From: Michael Eastham
Sent: 18 January 2019 15:52
To: Nicola Spencer
Cc: Karen Parsons; Planning.Responses
Subject: FW: *EXTERNAL: LU/283/18/DOC - Kingley Gate

From: Michael Eastham <Michael.Eastham@arun.gov.uk>
Sent: 12 January 2019 10:22
To: Kenny, Darren [REDACTED]
Cc: Joe Russell-Wells <Joe.Russell-Wells@arun.gov.uk>; Sparkes, Jessica [REDACTED] Fatima Evernden <Fatima.Evernden@arun.gov.uk>
Subject: *EXTERNAL: LU/283/18/DOC - Kingley Gate

The current discharge of conditions application (LU/283/18/DOC) for Kingley Gate includes a new location for the changing facilities building; additional car parking spaces and a new location for the NEAP from that which was granted under the approval of reserved matters (LU/282/17/RES).

Drawing Number	4485/259	Rev.	G
----------------	----------	------	---

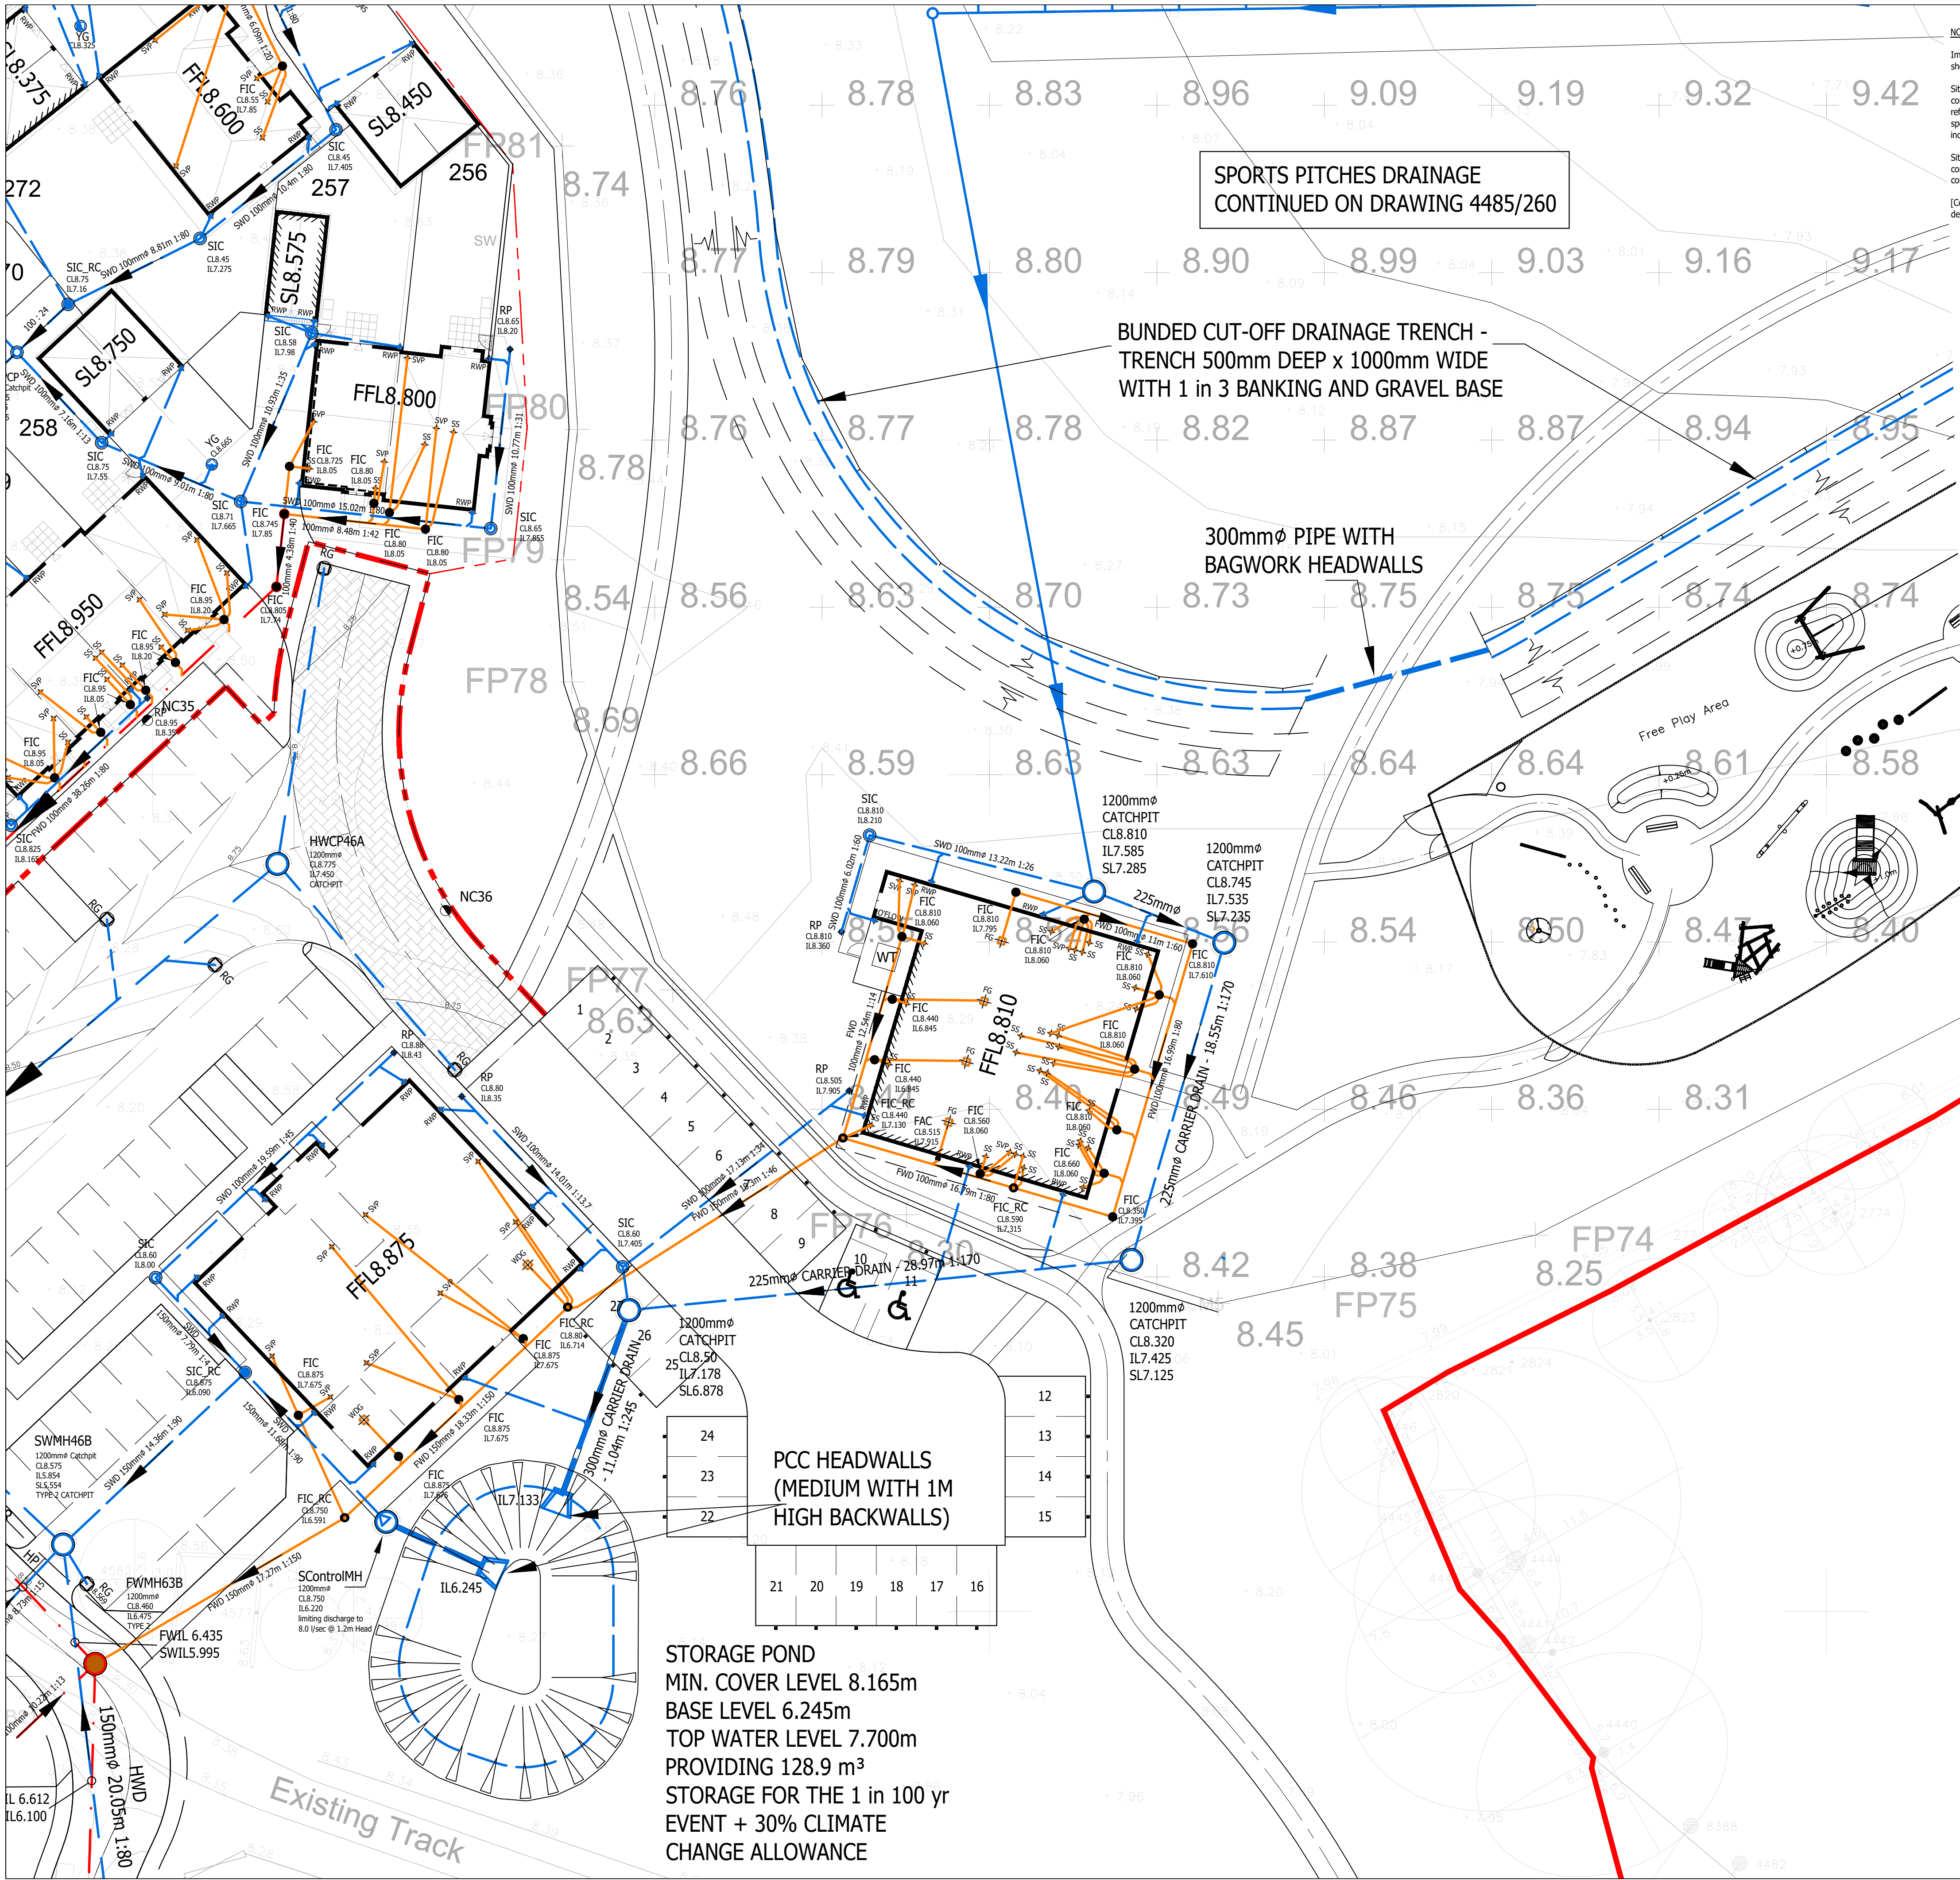
Consequently, the LPA is requesting that you withdraw LU/283/18/DOC and submit a planning application for the new location of the changing facilities building, the new location for the NEAP and the provision of additional car parking spaces. The new planning application would also need to cover the siting of the re-aligned sports pitches and the drainage ditches (i.e. swales) around the pitches and the proposed new attenuation basin.

Reserved matters submission covering community unit, associated parking, NEAP, sports pitches and drainage. No further DoV to s106 required.

Drawing Number	4485/257			Rev.						
				M

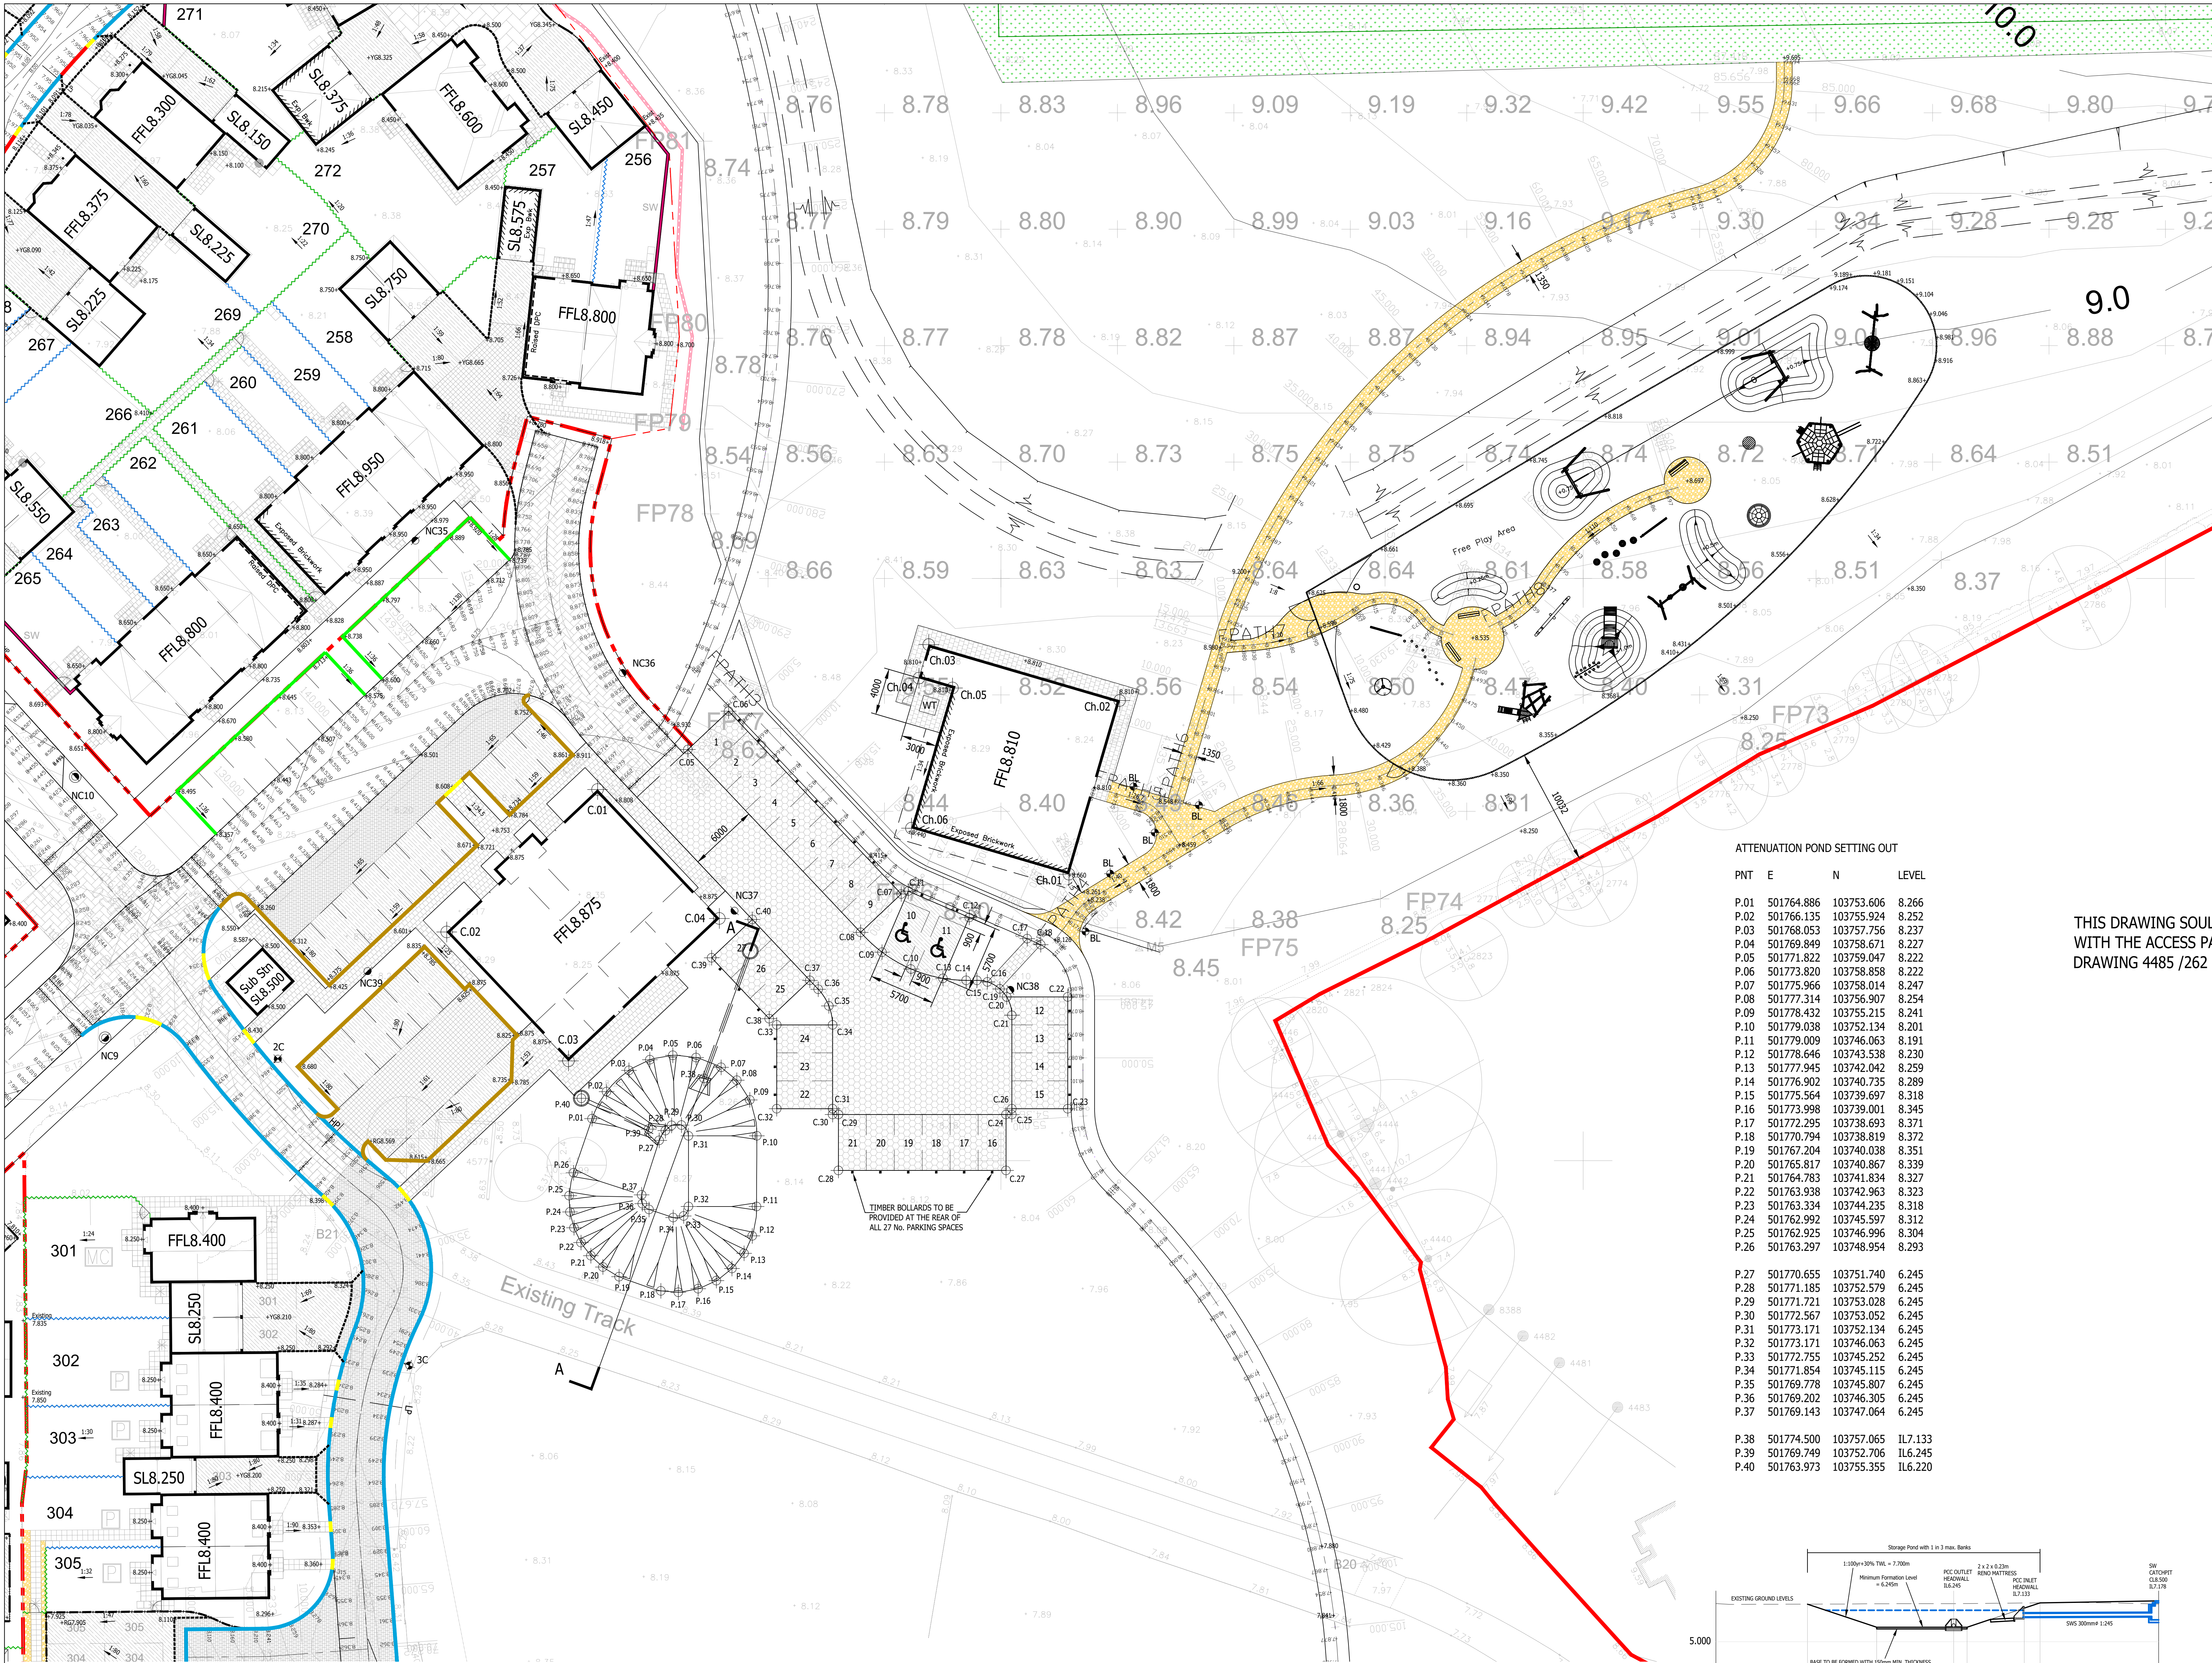
As such, the proposed changes cannot be covered in a DOC but should be the subject of a separate new planning application.

As discussed, please withdraw application LU/283/18/DOC.
